# OBSERVATION/SUBMISSION TO PLANNING APPLICATION

Case Reference: 324113

**Re: Observation to the proposed development of open-cycle gas turbine (OCGT) and generator with ancillary equipment.**

Location: Pollnagroagh and Rathmorrissy (Townlands), Athenry, Co. Galway

**SIGHTLINES AT ENTRANCE**  
 1:250

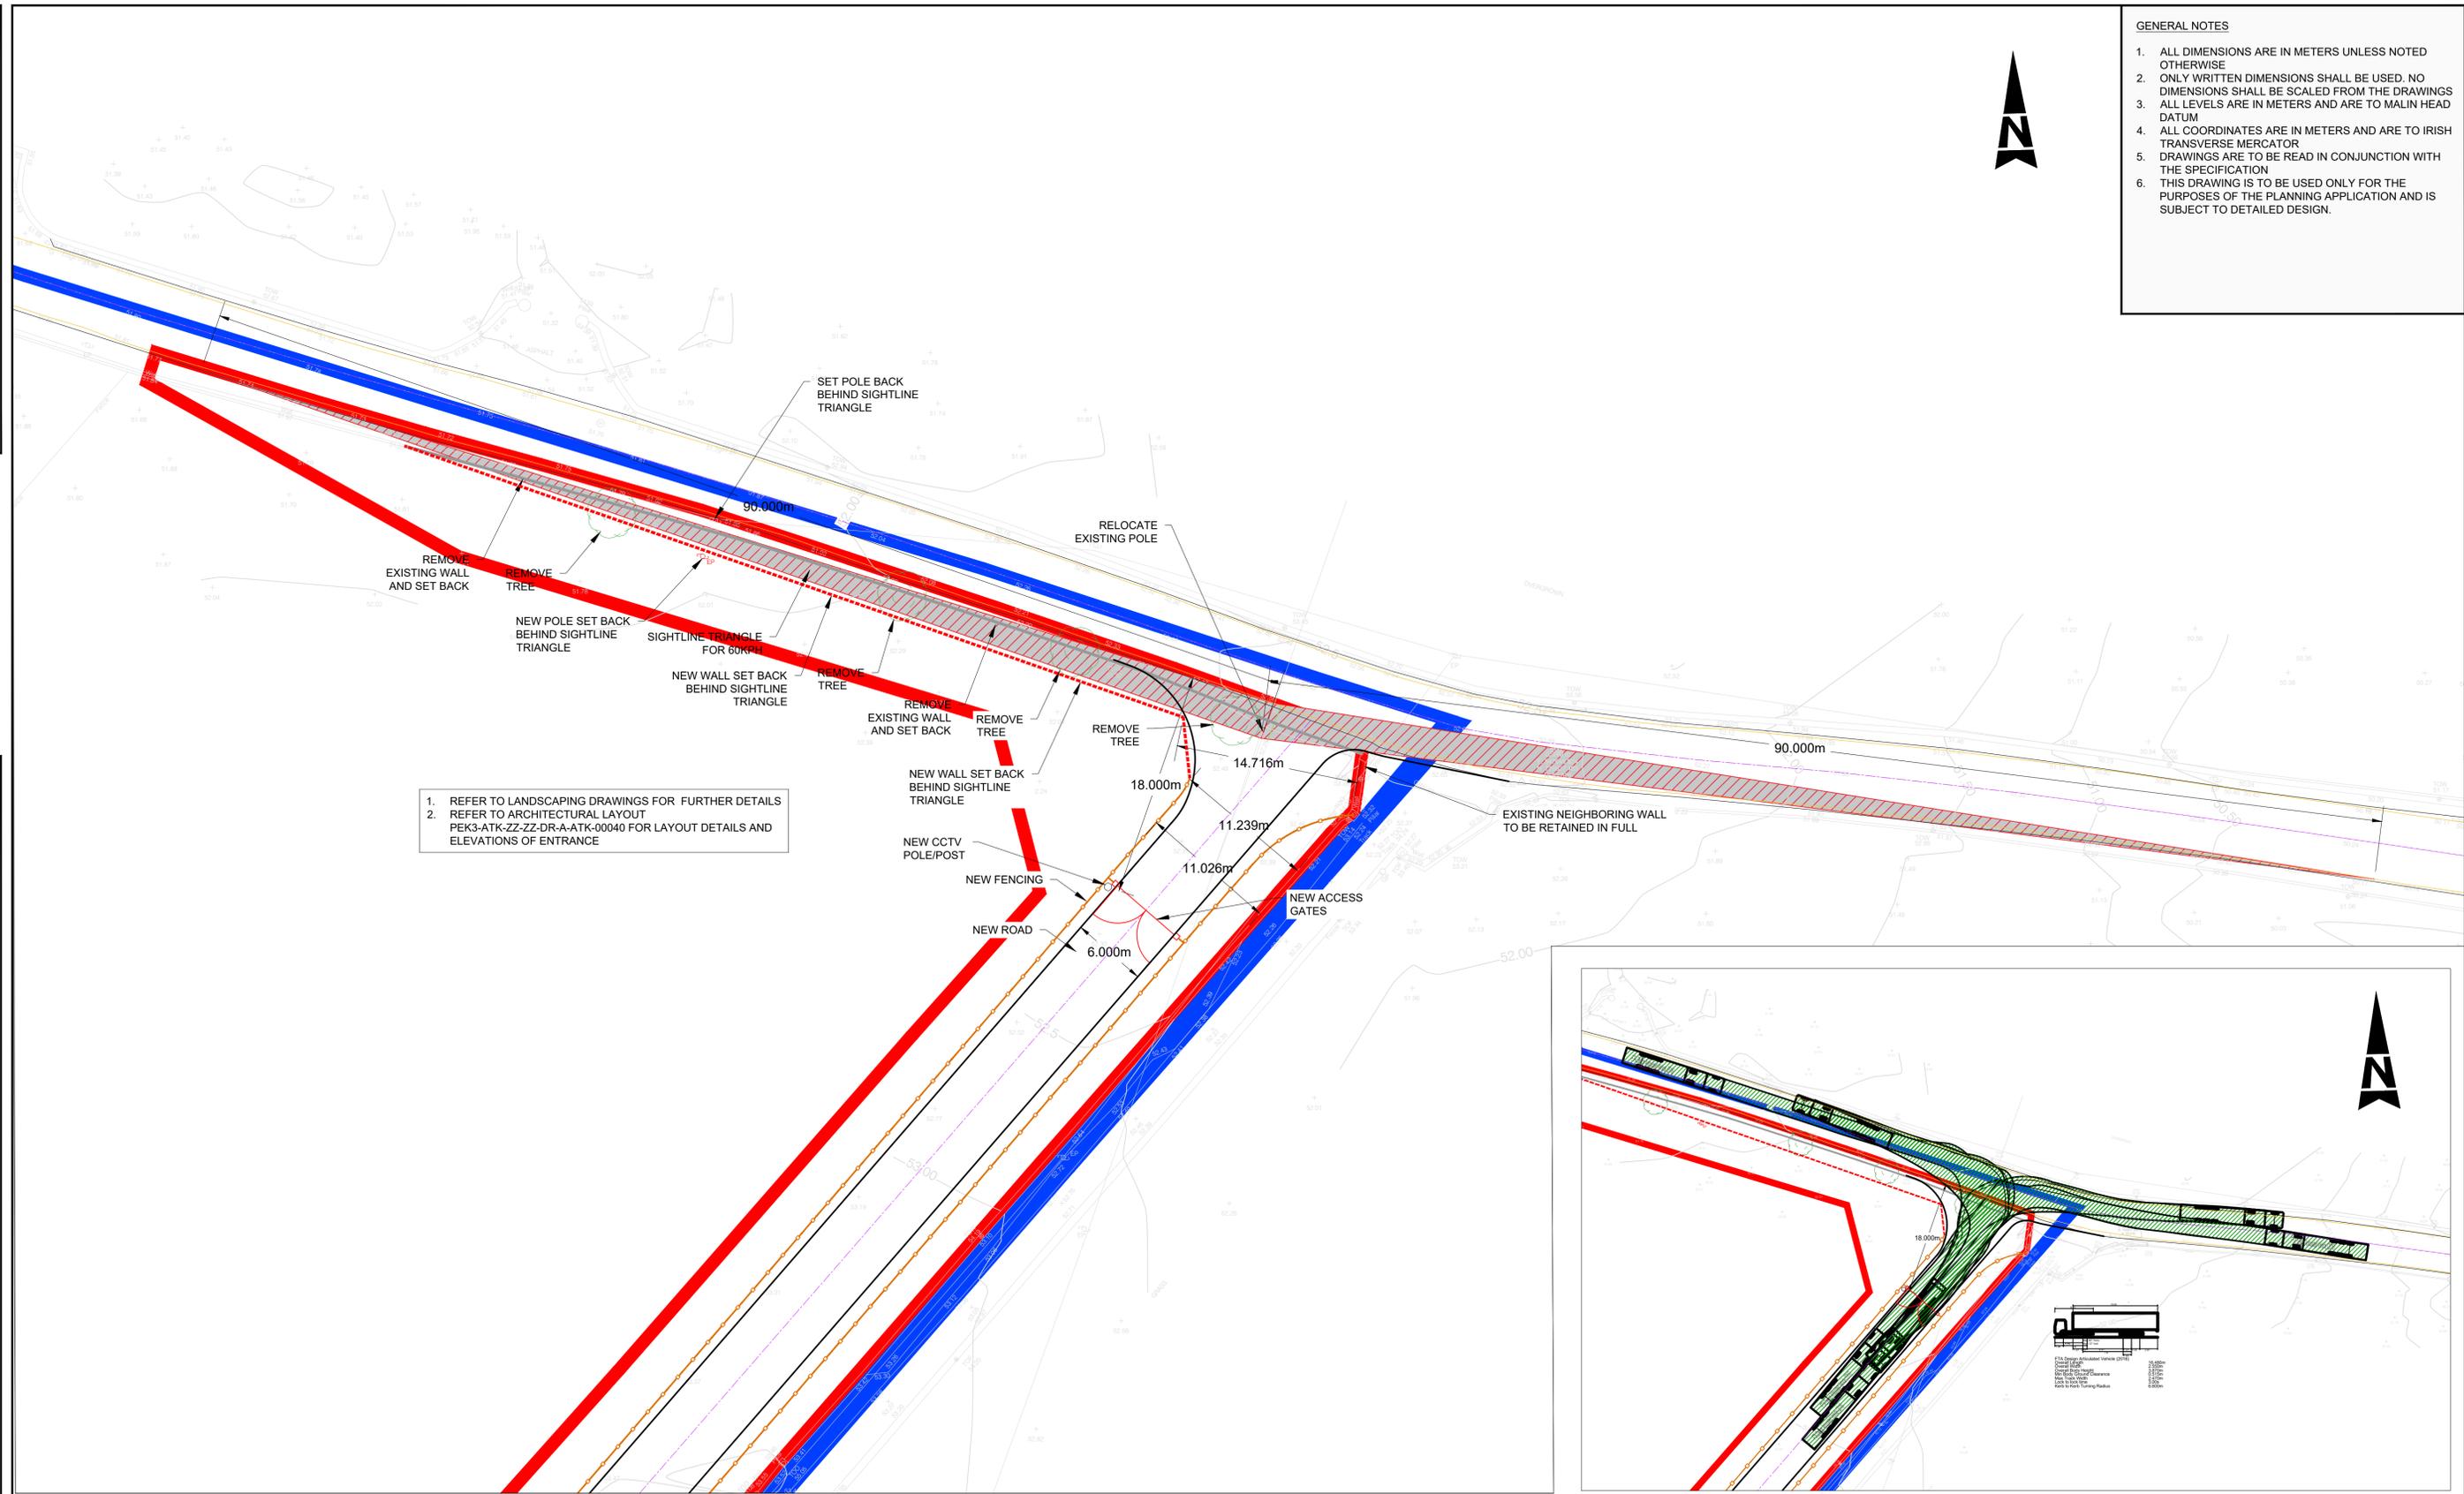
As someone who lives locally and uses this road, I am concerned about road safety in relation to the proposed entrance on the L3103. This stretch of road is already extremely narrow, with no hard shoulder, making it difficult for two heavy goods vehicles to pass safely and leaving no margin for error. Visibility is also poor due to blind dips and sharp bends, meaning drivers often cannot see oncoming traffic in time. The proposed development would increase traffic levels, including heavy goods vehicles, construction traffic, and fuel deliveries such as diesel tankers, all of which require space and clear sightlines that this road does not provide.

Given that these rural roads are used by residents, farm machinery, and school-related traffic, the addition of significant industrial traffic would increase the risk of accidents and create a more hazardous environment. Overall, there is strong concern that the existing road infrastructure is not suitable for this level of traffic and that the associated safety risks have not been adequately addressed.
